From: Jason Humphries [REDACTED]
Sent: 14 October 2019 13:52
To: Zac Denton <Zac.Denton@arun.gov.uk>
Subject: Re: AB/39/19/PL - Query on application

LOCATION AND BLOCK PLANS
DATE: March 2017
SCALE: 1:1250 @ A3
JOB No. 1010
DRWG No. HS_000 Rev.

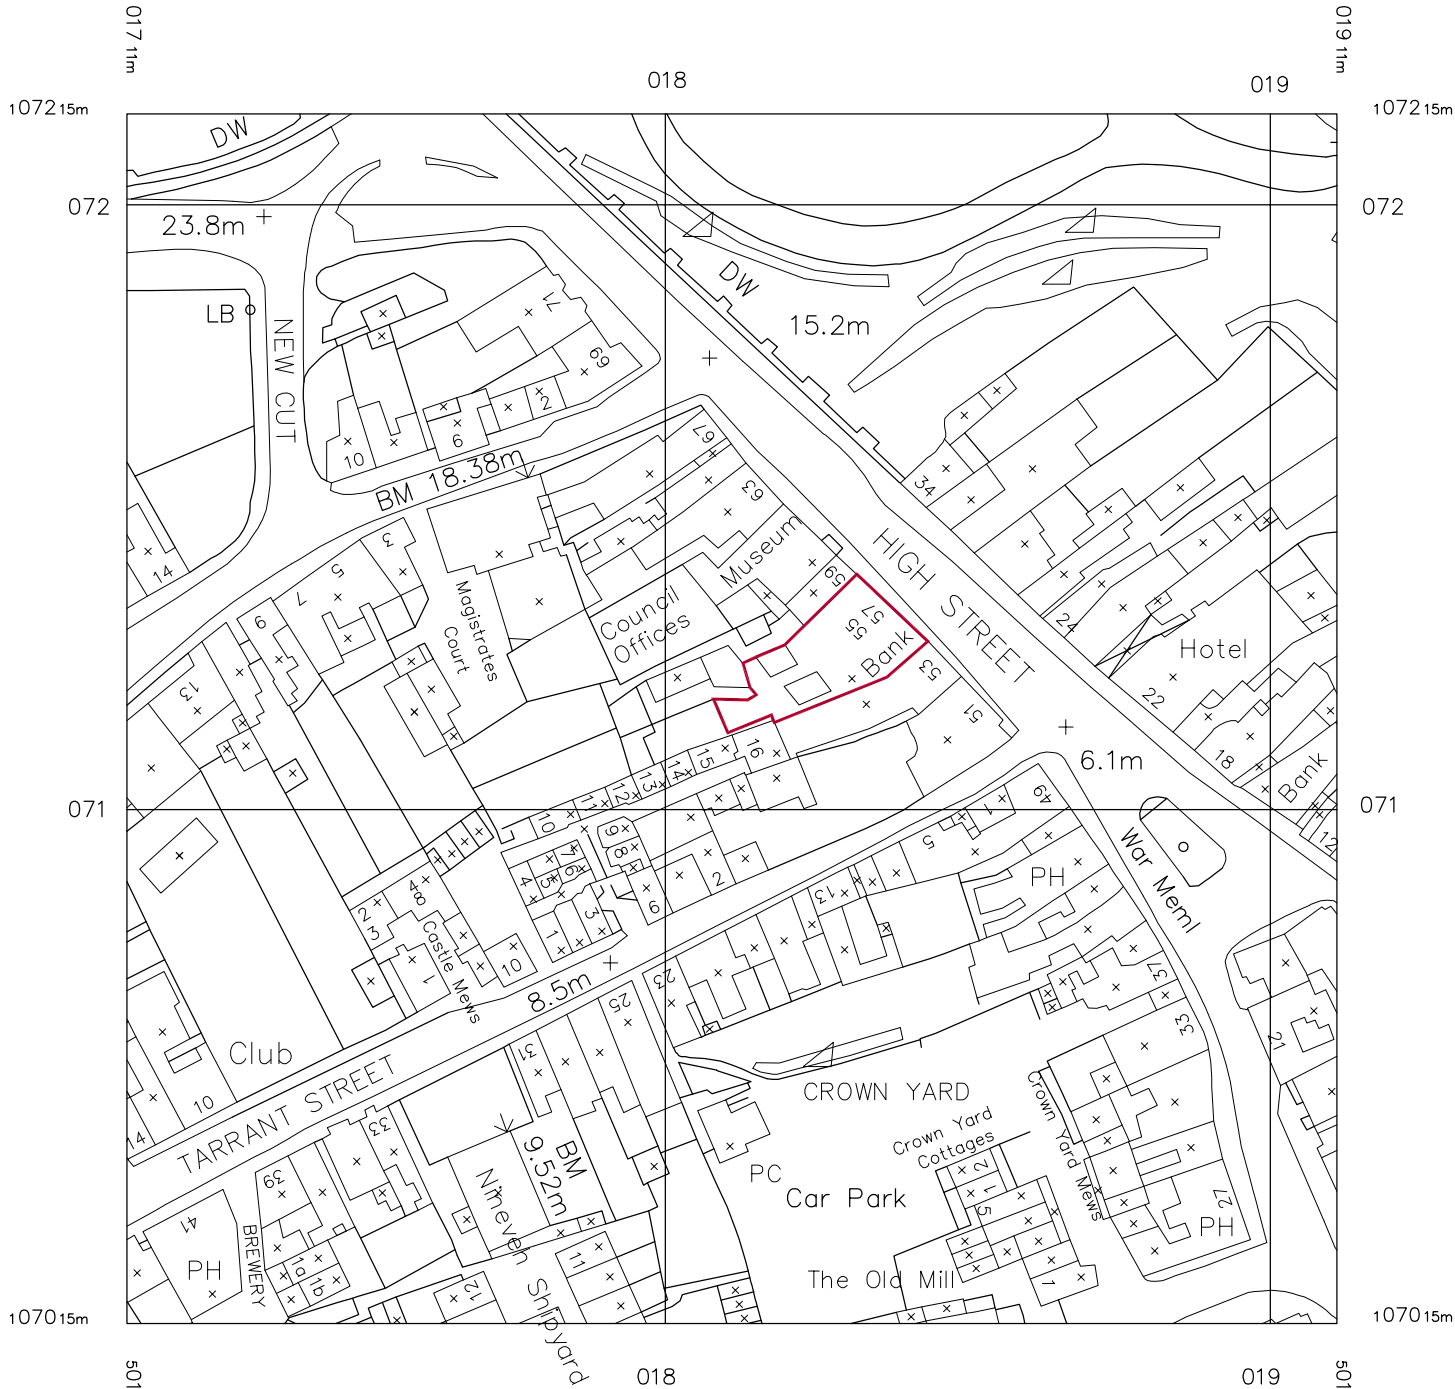
There are differences between the plans submitted, and what was approved under the previous application. Will the previously approved residential area in the South-Western corner of the site also form part of the change of use?

What is the proposed use of the outdoor courtyard area, does this remain residential?

SCALE. 1:100 @ A3
JOB No. 1010
DRWG No. HS_S01 Rev.

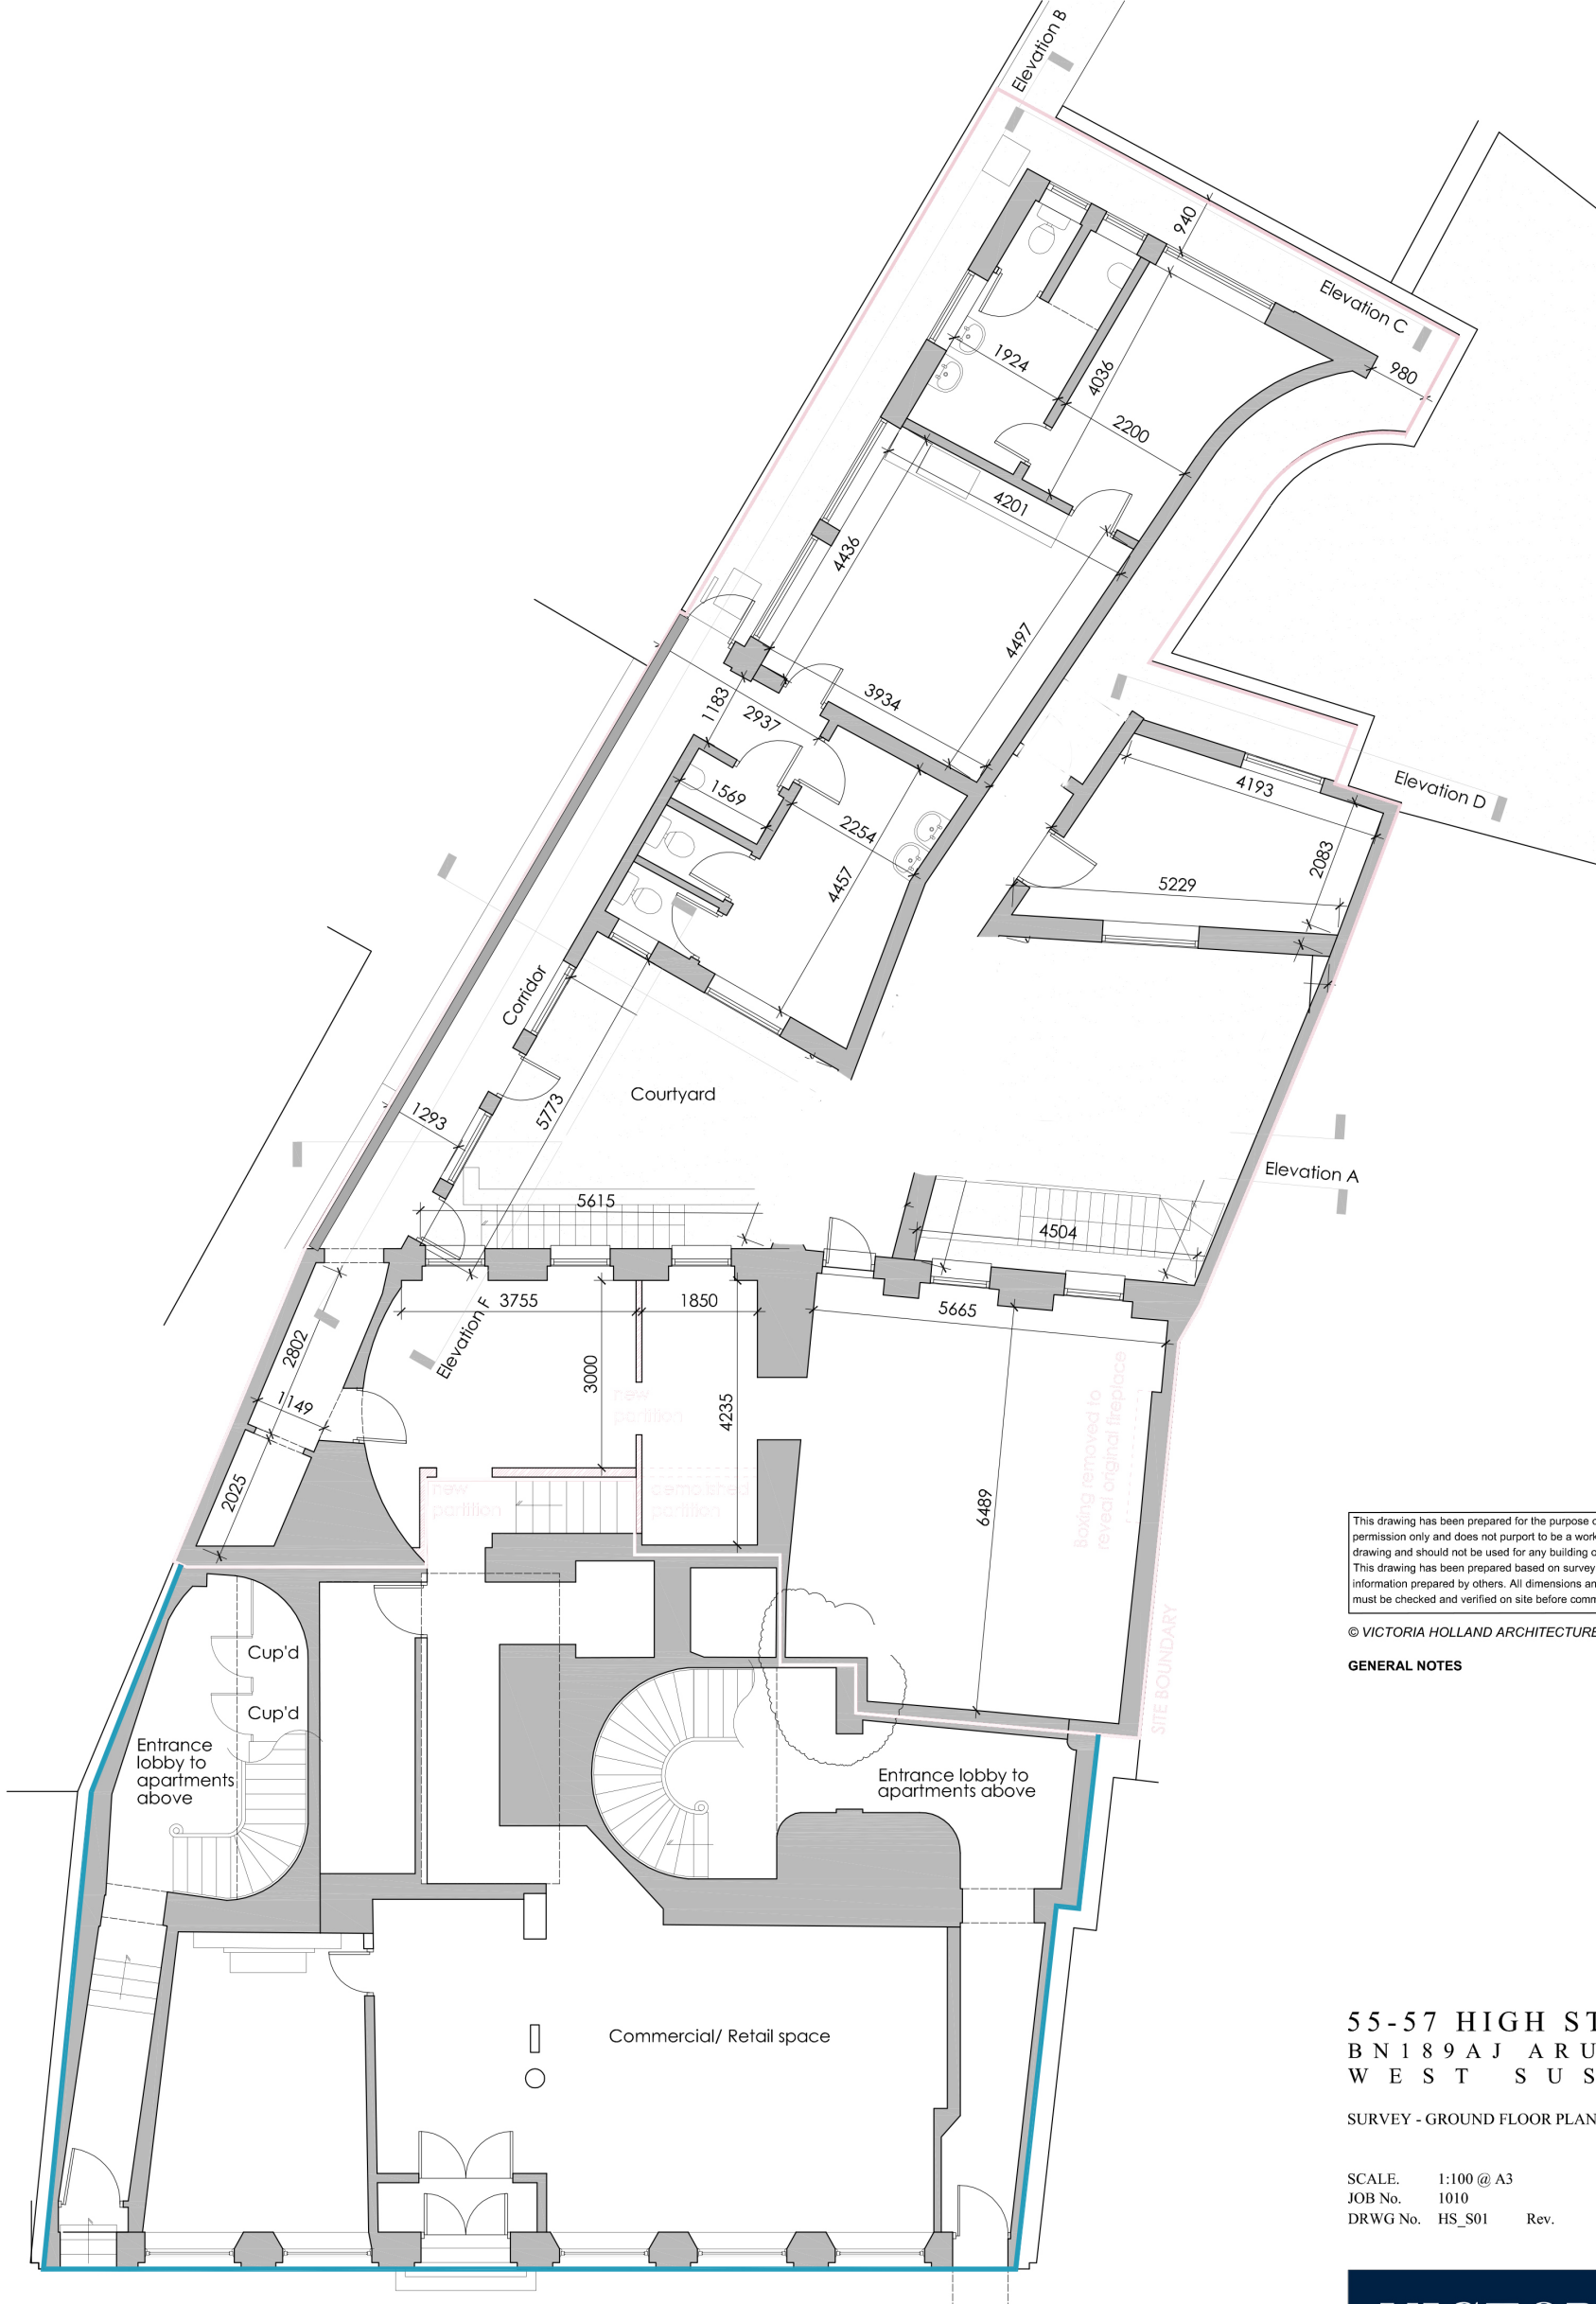
The area of land bordered by the red line on the block plan includes a residential flat, can you confirm that you are wishing to change the use of this to A2?

It would appear on the proposed plan 'HS_S01', that it does not change from 'Studio flat'.

Hi Zac – thank you for your email. I think your question is answered by my reply to your colleague Sian on 25th May – let me forward that to you and then perhaps get back to me if further clarification is required?

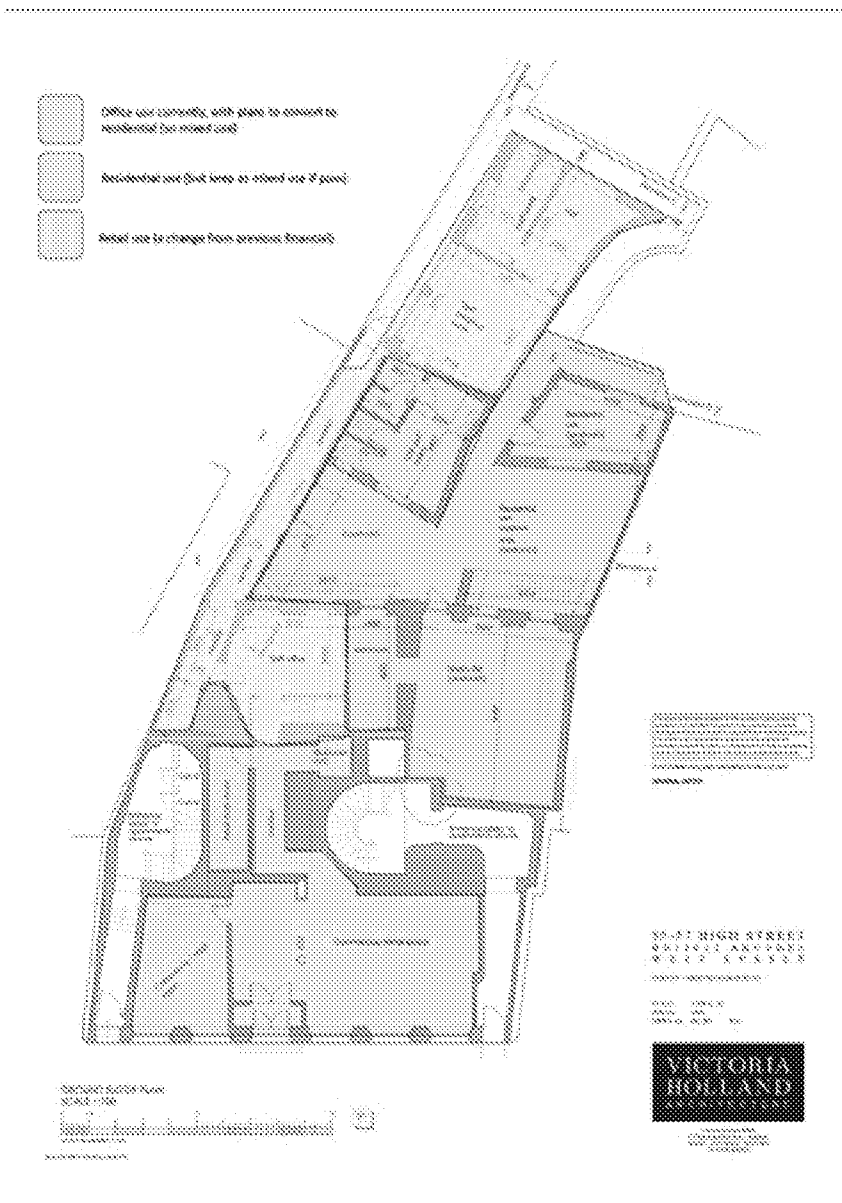
- Convert A2 (office) use, to C3 use (residential) – Shown as blue
- Retain C3 use – Shown as Green
- Convert A2 use, to A1 use – Shown as Red

Is this correct? The application needs to advertise all of the proposed changes, so this will need to be clarified before any further steps are taken.

- The area in BLUE we are currently using as office space/facilities for our wine business (which is the backbone to the retail part of our business operating out the red portion of the map, although our business is not purely about this retail space – we call this office area our HQ), but the landlord remains interested in converting this part of the space at some point to residential per the plans she has approved. So if poss this should become 'mixed use', I assume B1+C3 would fit the bill

- The area in GREEN is currently residential use (per partial completion of the landlord's approved plans), so I assume C3 (but if poss we had suggested this is also mixed use to allow it's use as an office as indeed it was when it was the bank, so C3+B1 would fit the bill – and as such the GREEN and BLUE areas could be merged)

- The area in RED, correct becomes A1 and is the simplest part of all this (and was behind my original request for change)
